Application number: 2023/91327	
What is the application for?:	Erection of detached dwelling
Address of the site or building:	adj, 152, Somerset Road, Almondbury, Huddersfield, HD5 8HY
Postcode:

Type of comment: An objection	
Do you wish your comments to be published on the website anonymously?	Yes
<p>These comments should be read in conjunction with those raised against application number 2020/62/91049/W</p> <p>Plan drawing</p> <p>There appears to be an error on the plan submitted relating to the boundary adjacent to the garage plots at the rear of the property. The boundary line does not run up to the garage as shown but in fact continues in a straight line following the rear boundary of 152 and the other adjacent properties. There is a passage/accessway along the side of the garage which is not owned by the developer.</p> <p>Parking and vehicle access</p> <p>Parking is currently a huge issue and, as it stands, this design will make it significantly worse. The kerb modifications will result in the loss of at least one, possibly two existing parking spaces in an area where parking is at a premium. The kerb modifications (if permitted) and car/gate access should be carefully aligne

SKETCH SECTION FACING NO.152 SOMERSET RD.
(NOT TRUE TO SCALE)

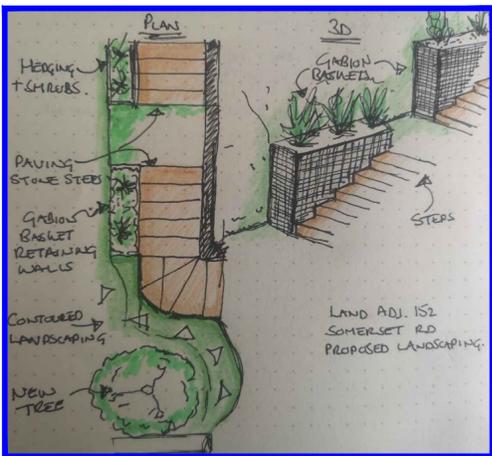
The excavation and foundations of the new development will be less than two meters from number 148. 148 is a 1900's stone built property which does not have the benefit of modern construction techniques and foundations.

Removing substantial amounts of earth along even a short length of the property without suitable reinforcement or retaining walls in place may cause subsidence issues.

There is also no mention in the plans of any measures being taken to support the ground or the garage at the side of 152 whose outer walls lie on the boundary line.

DRAWING: PROPOSED LANDSCAPE PLAN

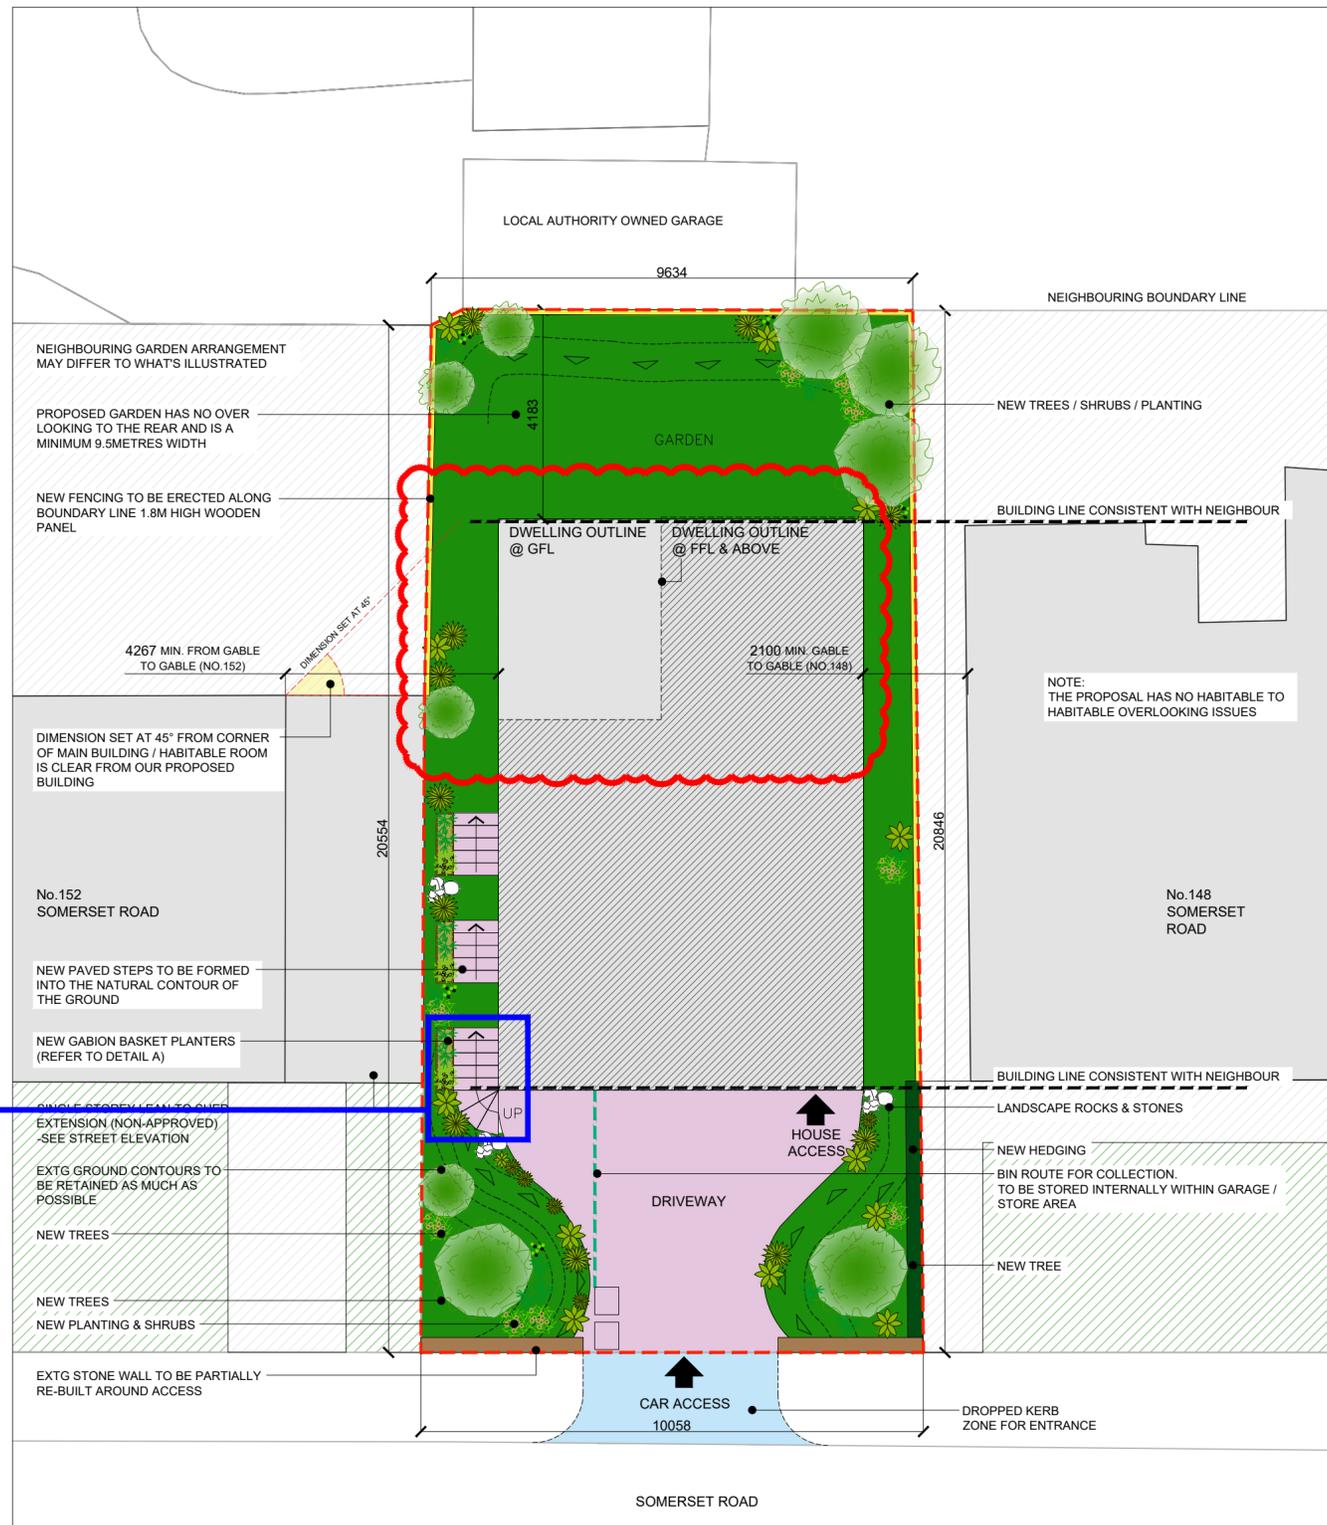
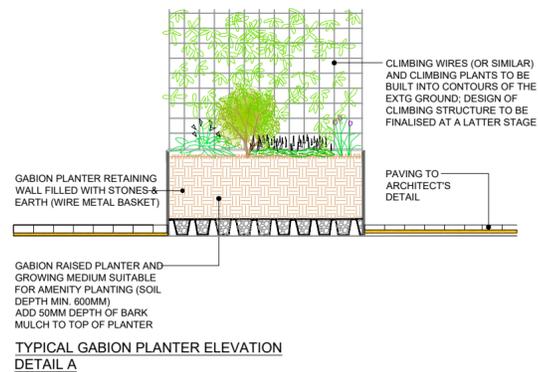
The front driveway has been modified from the previous plans and is now only suitable for one vehicle. With a car parked on the driveway, there would be limited access to the front entrance and to the rear of the property in case of an emergency.

The garden provision on the previous application only showed an area at the rear of the property which was approximately one fifth of the current plot resulting in a significant loss of 'green space'. This latest plan simply shows the previously flagged areas as being grass. This is impractical and will almost inevitably vanish once the property is occupied.

With regard to the new trees shown on the rear of the plan, if they are indeed planted where shown they will ultimately block the sunlight and shade the garden of 148.

DRAWING:
PROPOSED ELEVATIONS

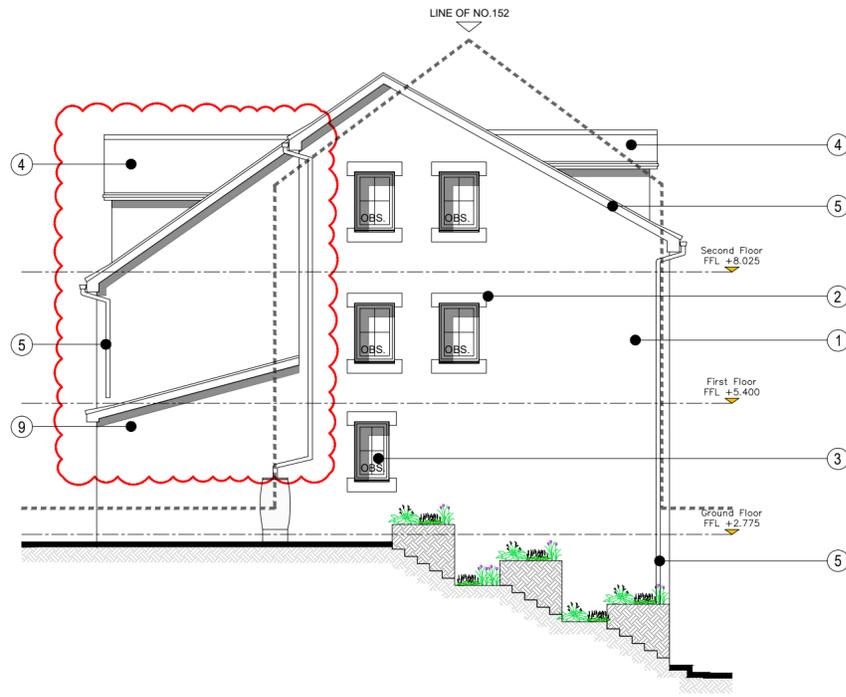
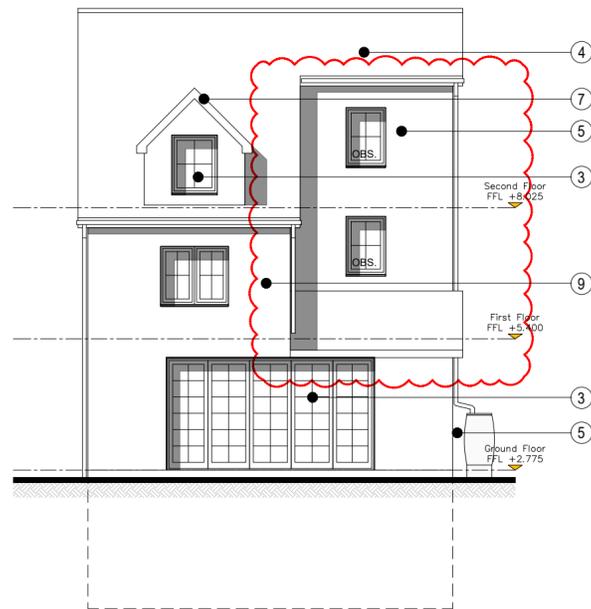
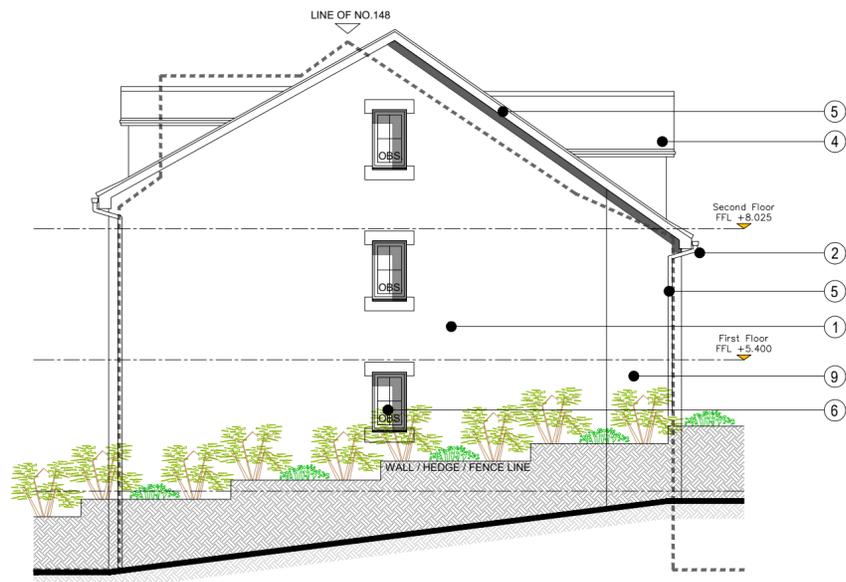
This is the third set of plans that the developer has submitted. The original application specified stone walls throughout and even though the building materials would have been modern it was broadly in keeping with the rest of the neighbourhood.

The second plan was for a stone frontage with the rest of the building being white render which would have been completely out of character with the neighbourhood. The developer has now revised this again but still the rear and part of the sides is rendered.

None of the surrounding buildings are rendered and the plans should be revised to use stone on all the outside walls as per the original documents.

In order to maintain the privacy of both the two existing properties and the new development, all the windows on both side elevations of the new property should be fitted with obscure glass.

DRAWING:
PROPOSED GA PLANS

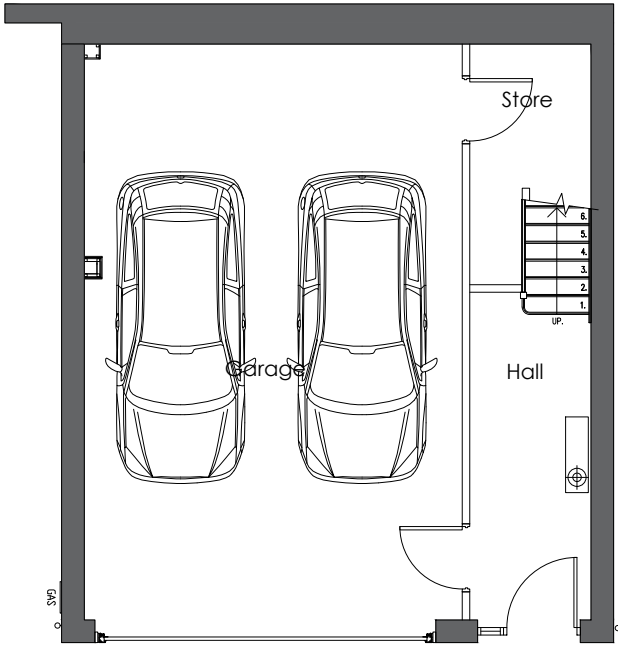
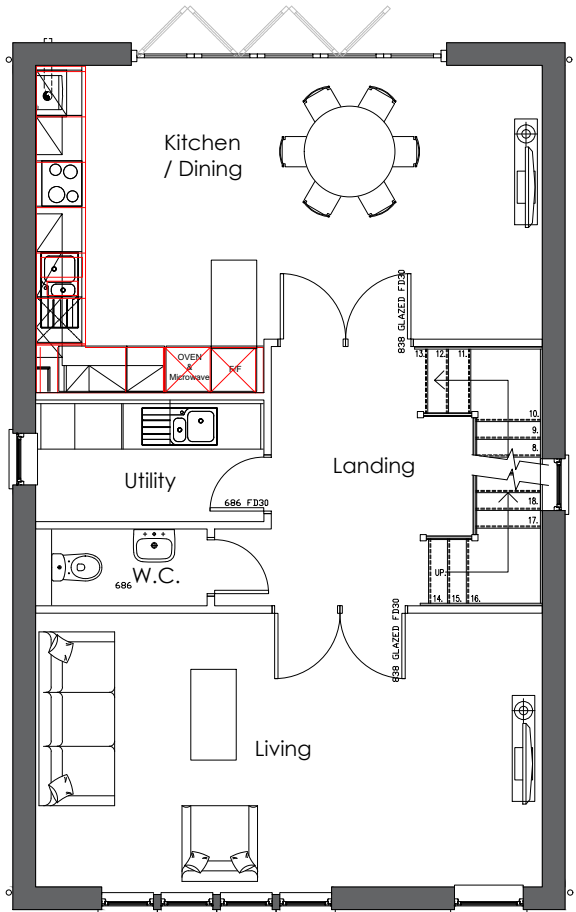
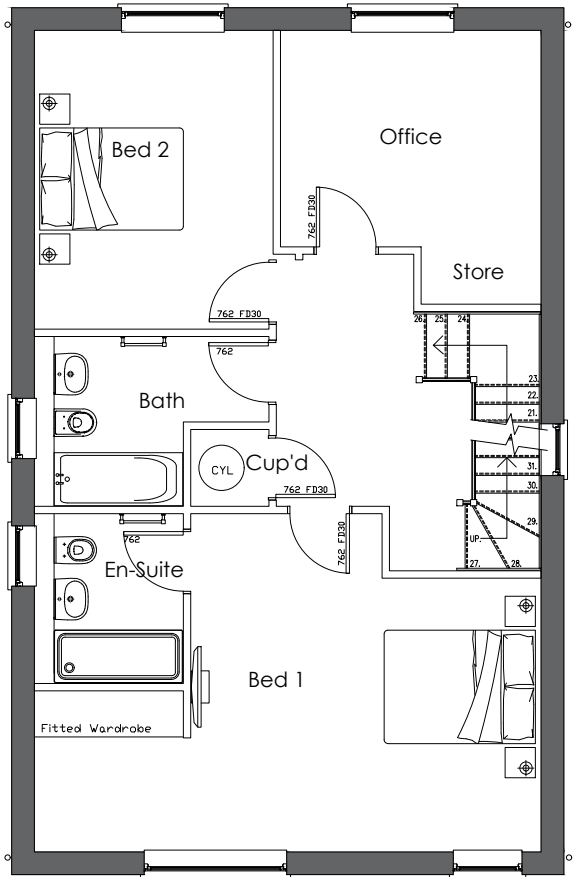
impossible for anyone to walk between them. Even then, exiting and entering the second vehicle would be a challenge for all except the smallest of drivers.

The bin collection route states that the bins are to be stored within the garage. This in turn will limit the space within the garage even more making it almost impossible to keep both bins and cars inside.
